2 November 2016

CR2016/004474  
SF2012/004409  
TR

WINE COUNTRY DRIVE (B82): NOTIFICATION OF SECTION 75W MODIFICATION TO STAGE 1 PROJECT APPROVAL FOR HUNTLEE NEW TOWN, WINE COUNTRY DRIVE, BRANXTON (MP 10\_0137 MOD 6)

Appendix B Hyder Report Figure E-1

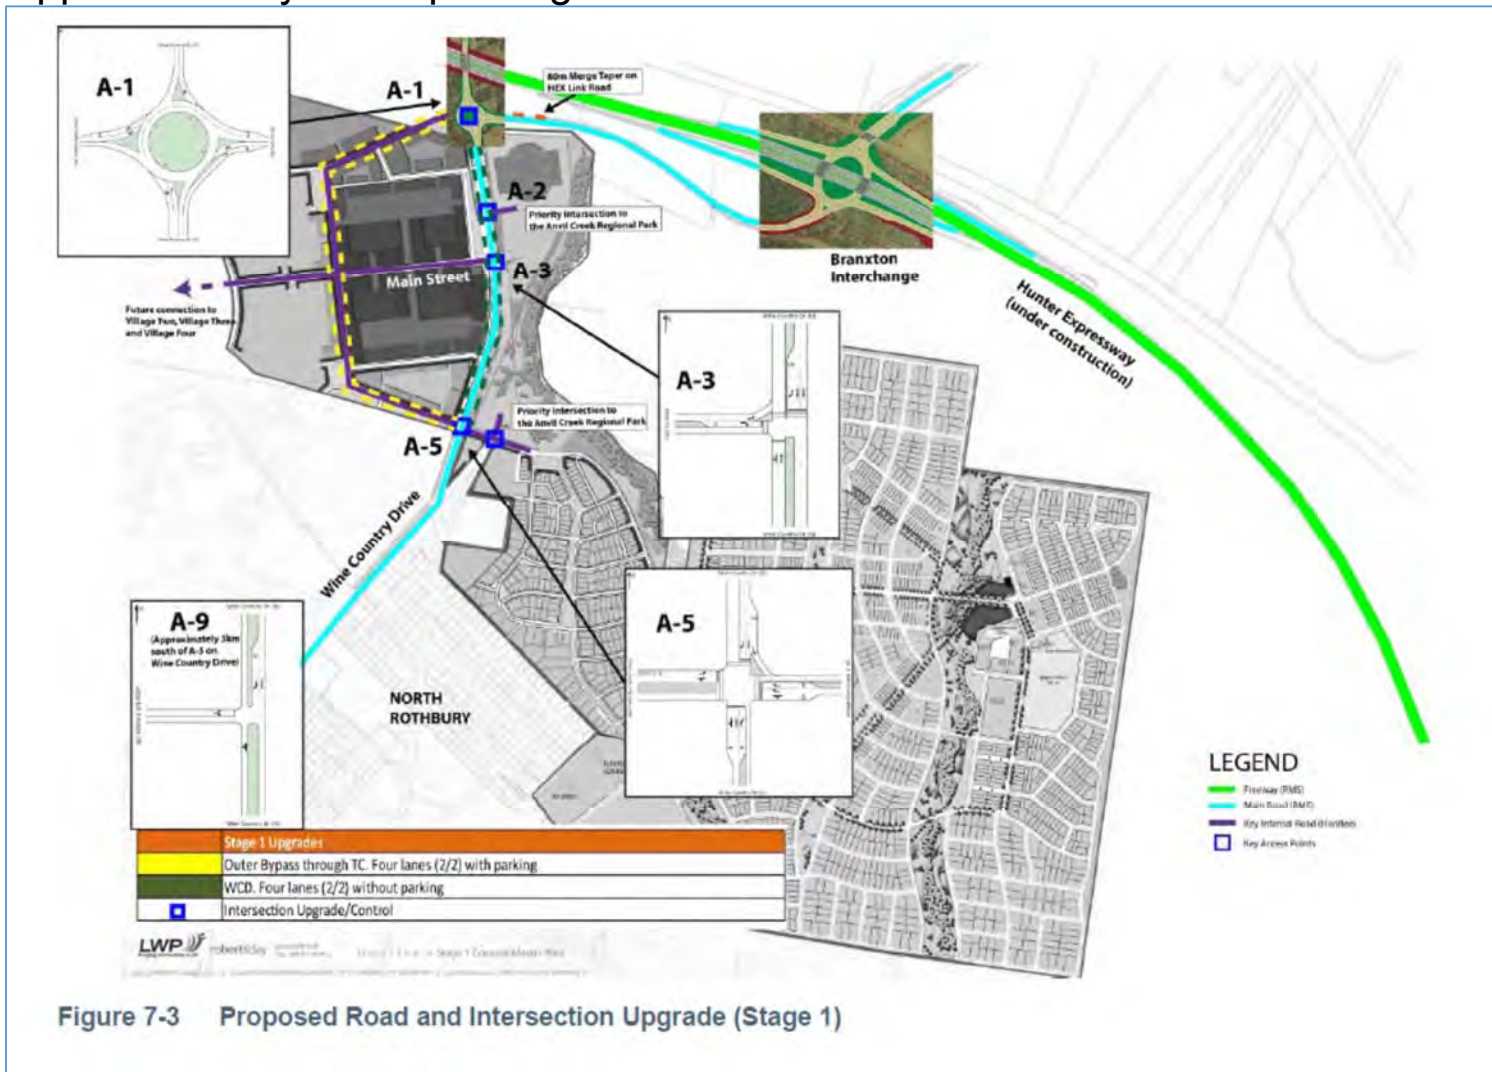
- The traffic analysis undertaken by Hyder was based on comprehensive modelling which included a road based micro-simulation model for the study area as well as intersection analysis, using SIDRA.
- The Hyder report clearly considers modelling of network scenarios for Stage 1 and full development of Huntlee.
- The outcome of this analysis demonstrated that *Wine Country Drive widening between Entry Village one access and HEX Link Road is the most critical upgrade required to accommodate Stage 1 development. Concurrently, key intersections with the Wine Country Drive are required to upgrade.*
- The road and intersection improvements in Figure E-1 of the Hyder report were recommended to cater for additional traffic from the Stage 1 development.

Figure 5: Traffic Infrastructure Upgrade – Stage 1 (Source: Proponent's Modification request)

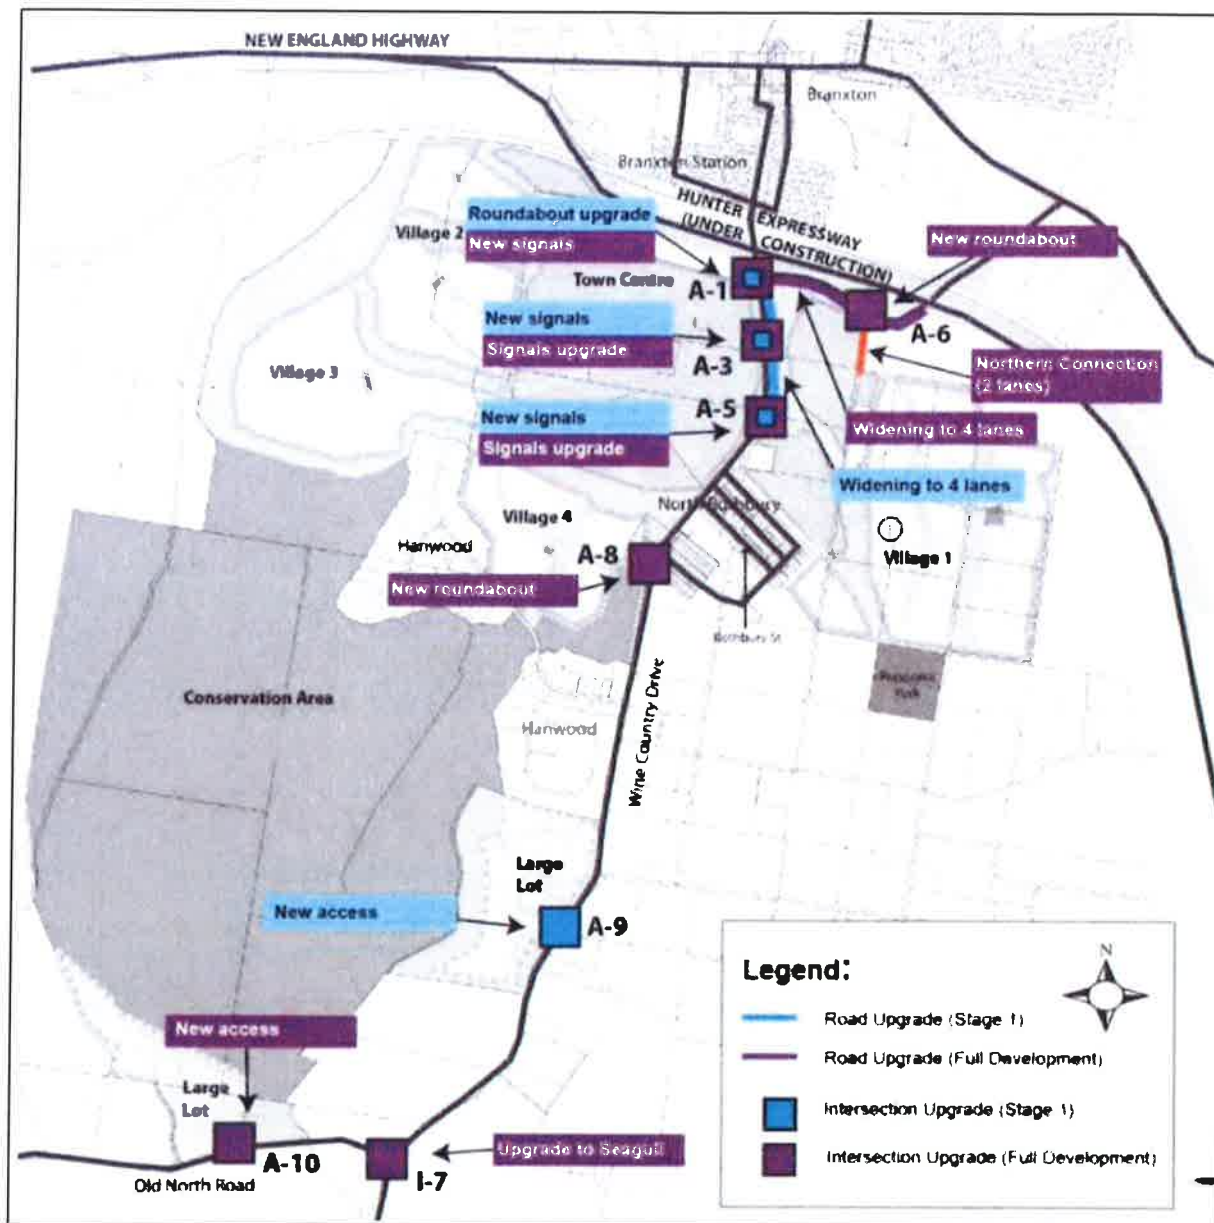
In particular the modification seeks to provide revised timeframes for the upgrade and completion of various traffic intersection and infrastructure works required under Condition E7 Road Network of the Stage 1 Consent (MP10\_0137).

Roads and Maritime considers that the traffic analysis undertaken by BTF is not adequate as it only considers individual intersection capacity of future upgrades and does not consider a future network of intersections which form part of the Stage 1 Huntlee approval.

Roads and Maritime requires the intersection analysis to include a network based model which includes all intersection upgrades as part of Stage 1 to be prepared in accordance with RMS Traffic Modelling Guidelines.

Accordingly, Roads and Maritime objects to the proposed modifications to Condition E7 of the consent and requires that the issues raised above be clarified and additional information be provided for further review and consideration.
